Ribble Valley Borough Council
Housing & Development Control

Application no: **3/2023/0157**

Address: **Black Horse Inn Pimlico Road Clitheroe BB7 4PZ**

Proposal: **Approval of details reserved by conditions 4 (soft landscaping scheme), 7 (surface water drainage), 8 (programme of archaeological investigation and recording), 9 (construction traffic management plan) of planning permission 3/2022/0148.**

PROJECT:	Housing Development		
	Land Behind Black Horse Inn		
TITLE:	General Arrangment		
	Site Drainage Plan		
SCALE AT A3:	DATE:	DRAWN:	CHECKED:
1:200	23/01/20	MB	-
PROJECT NO:	DRAWING NO:	REVISION:	
0207	0207-201	A

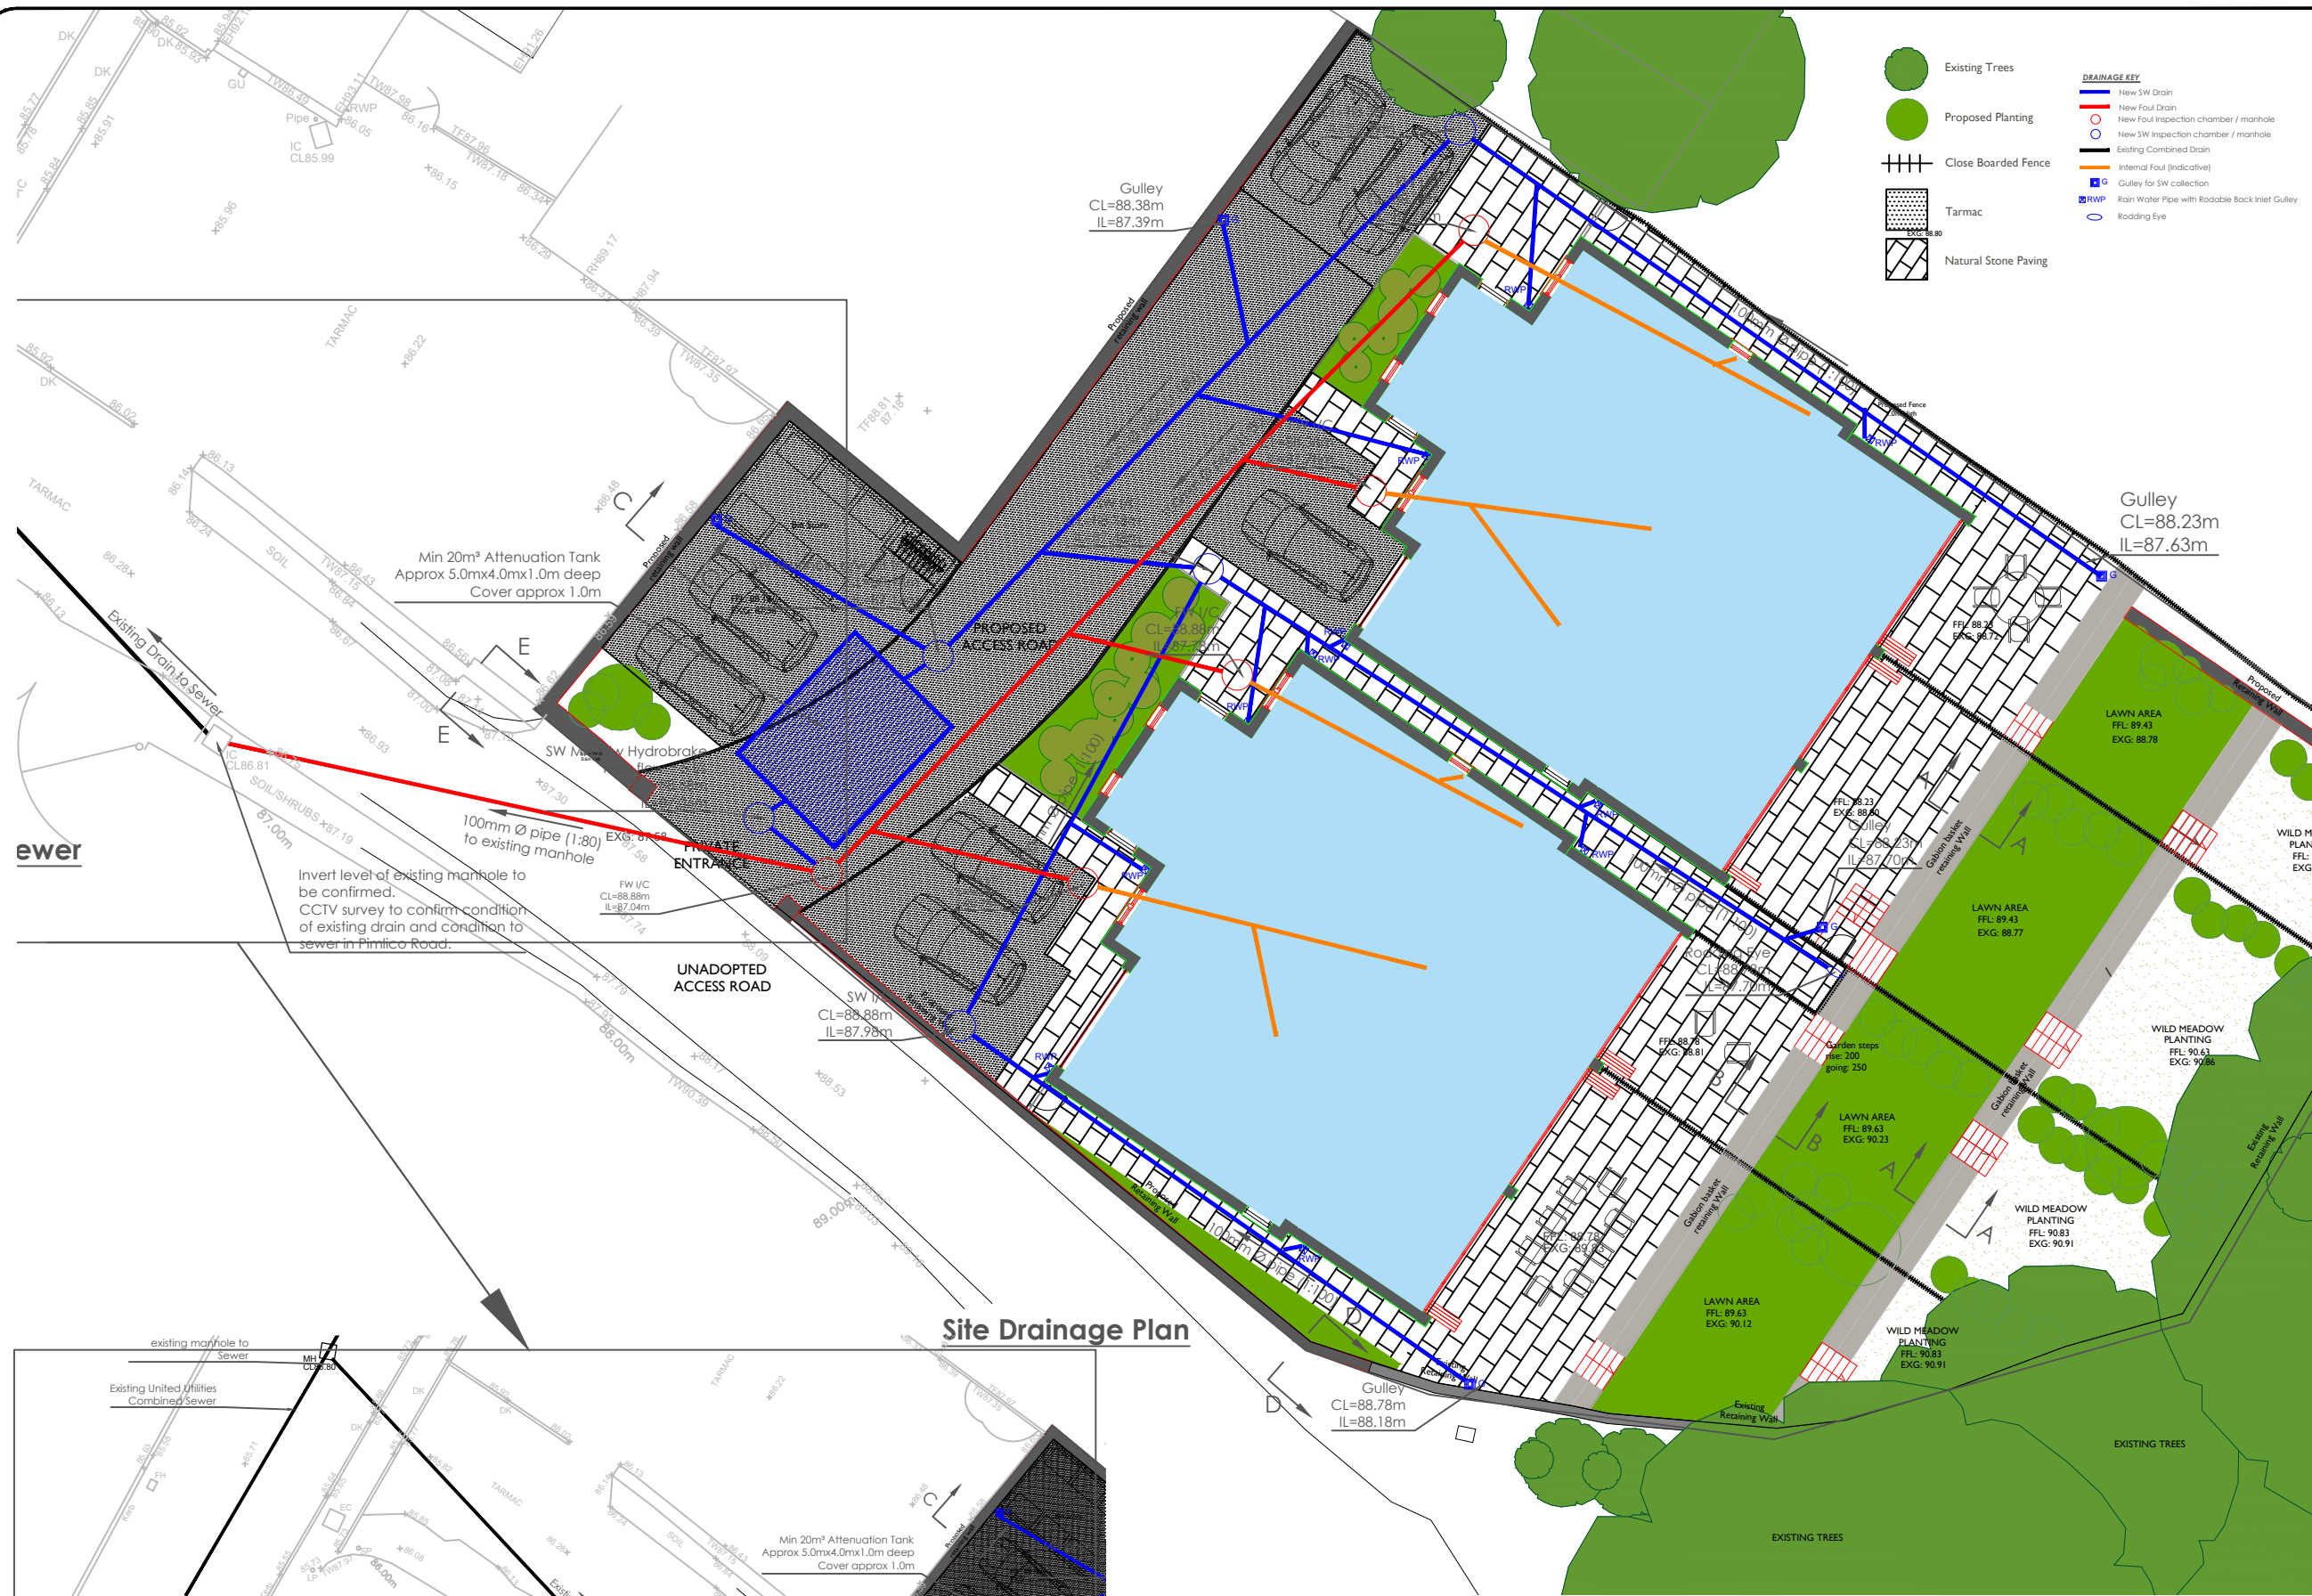
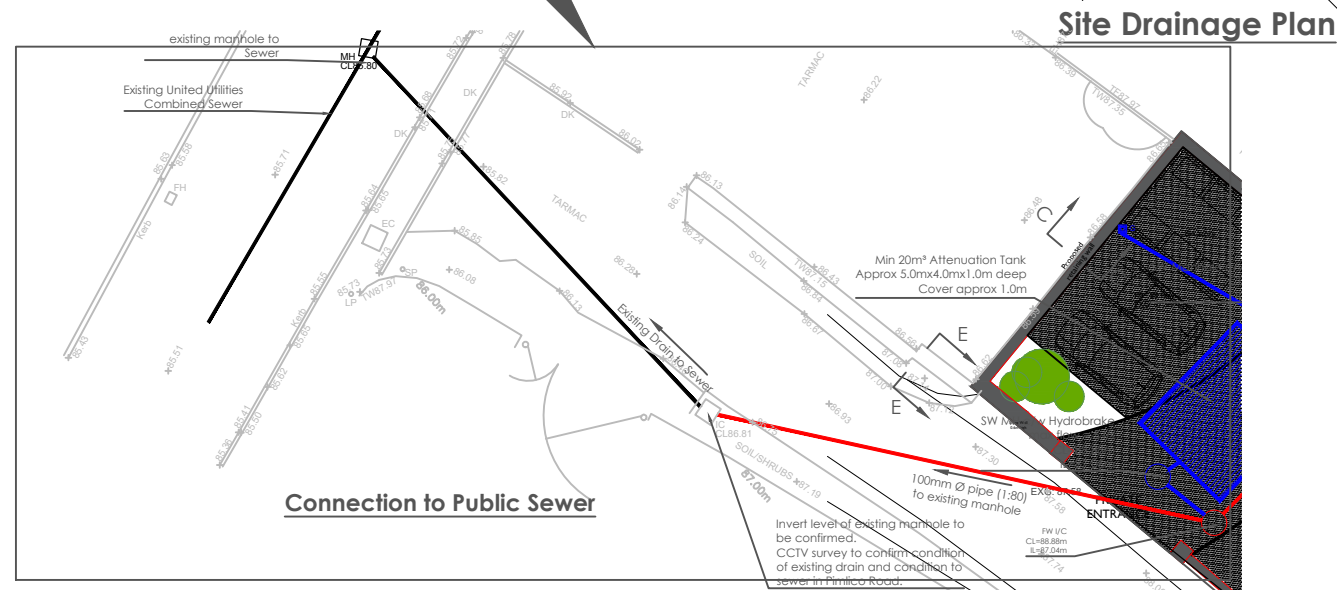
The LHA have reviewed PD drawing number 1194-01 titled "Proposed Site Plan" and require further information regarding where the surface water drain, labelled AC2, drains to. This is because the LHA are unable to accept drainpipes connecting to any highway owned drains or gullies.
